Responses to Any Further Information at Deadline 8

Application by Luton Rising to extend London
Luton Airport

Author: Luton Borough Council (the local planning authority [LPA])

Date: 30 January 2024

Figure 4.2: Comparison of London Luton Airport Scenarios with Gatwick Capacity of 67 mppa and 50 mppa based on Original Economic Growth Projections

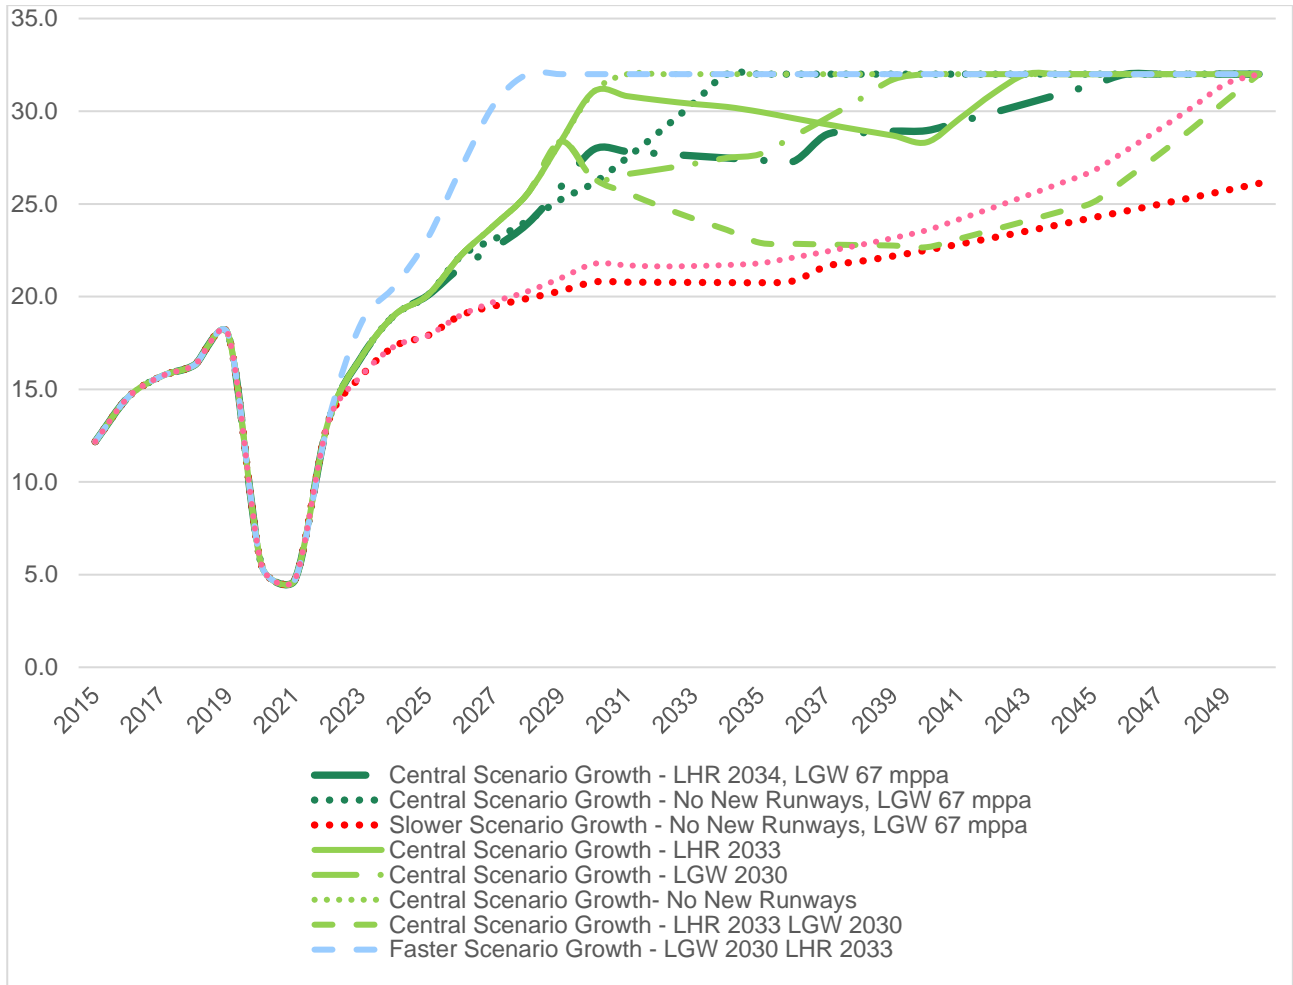
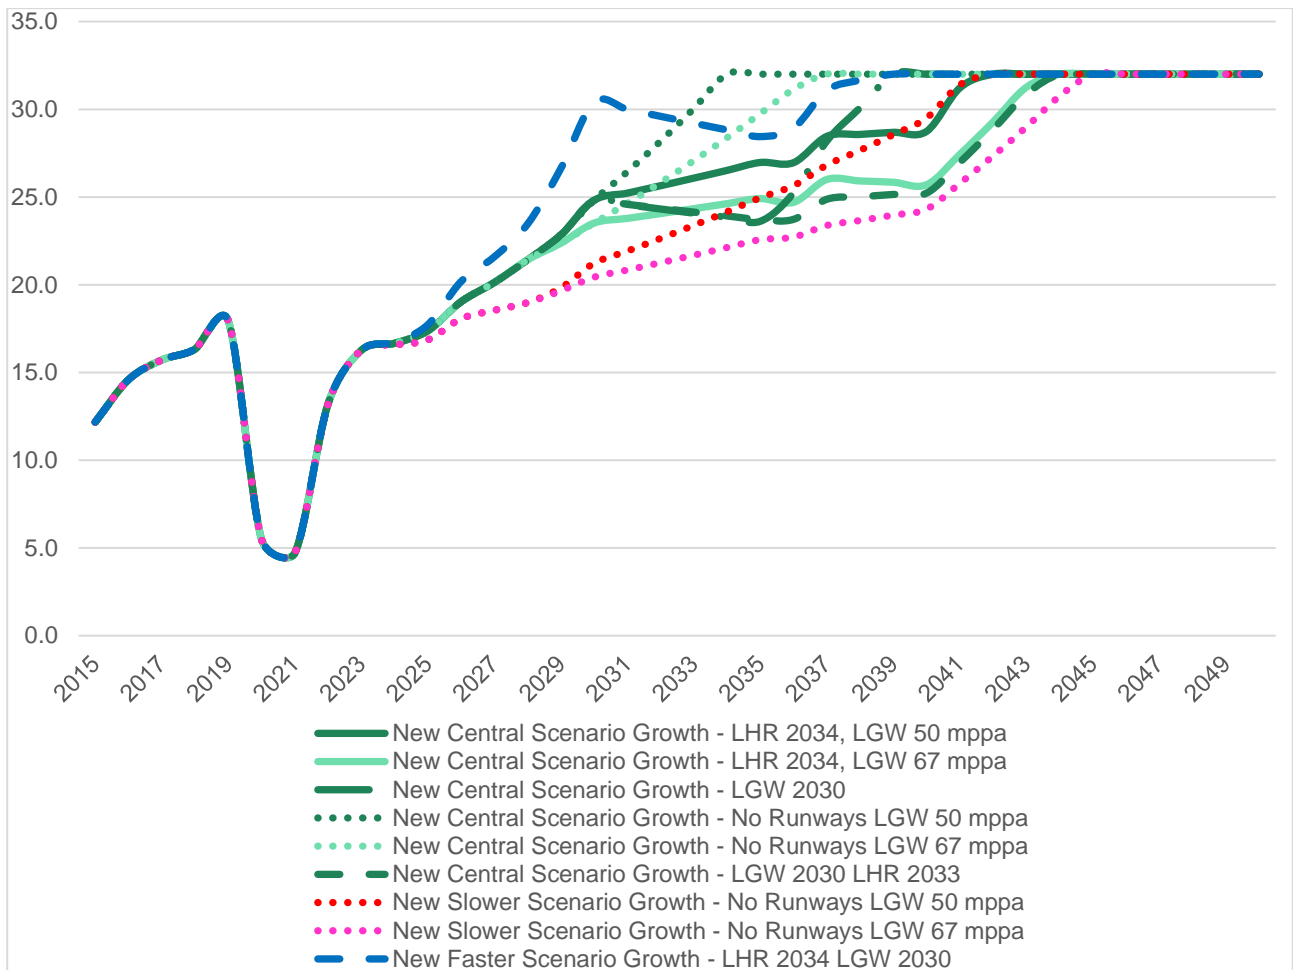
Reference	Subject	Comment
General	Gatwick Airport Passenger Handling Capacity	The Applicant has used a fixed figure of 50 mppa, while the Host Authorities advocate a gently rising capacity over time, with in the

<p>CSACL report of September 2023 [REP2-057] and illustrative figure in 2050 of 60.4 mppa being presented. Gatwick Airport has more recently published a figure of 67 mppa in 2048.</p> <p>The Applicant dismisses the use of a capacity for Gatwick of 67mppa on the basis that it is not the figure used by the DfT. This is not correct. The DfT figure used by York dates from a 2017 document, with the DfT's position now (and since at least 2022) being that growth in passengers per ATM means that there is no fixed capacity at Gatwick (or Heathrow). The figure of 67 mppa identified by the Host Authorities is that determined by Gatwick's own management team. A fuller more detailed response is provided in the separate CSACL Review of the "Applicant's Response to Written Questions NE.2.1 and NE.2.2 - Demand Forecasts" [REP8-037].</p>
--	--	--

Figure 3.1: Summary of proposed odour management process

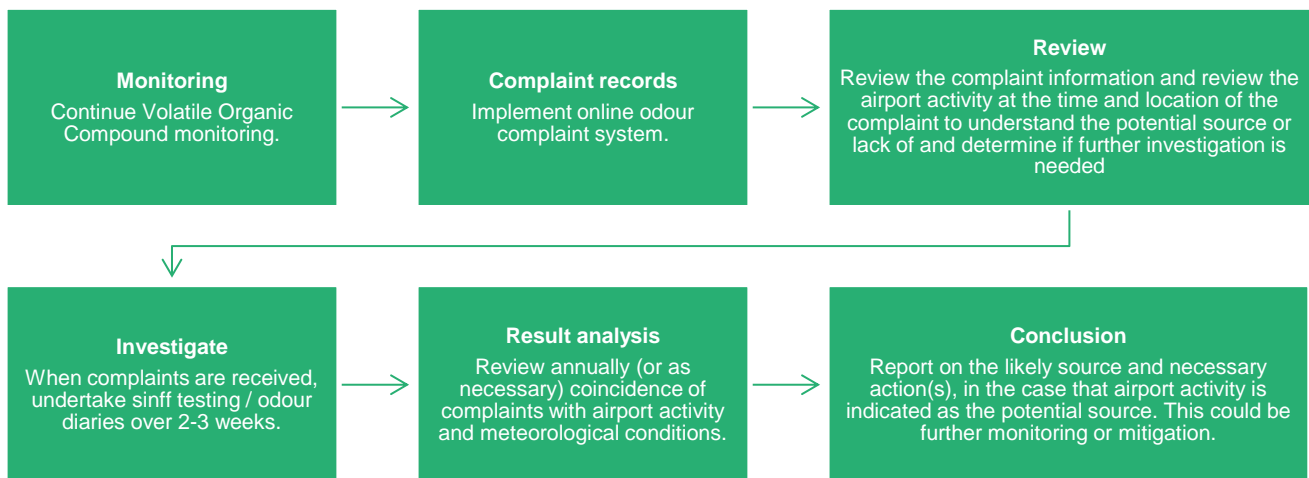
Reference	Subject	Comment
Para 3.1.1 and 3.1.3	Proposed Odour Reporting Process	At Deadline 8, LBC commented in our REP8-058 on I.D.1 in Table 1.3 of the Applicant's REP7-068 submission, noting that the odour reporting process had been agreed with the Applicant. The amendment to this document reflects what was agreed with LBC's environmental health officer.
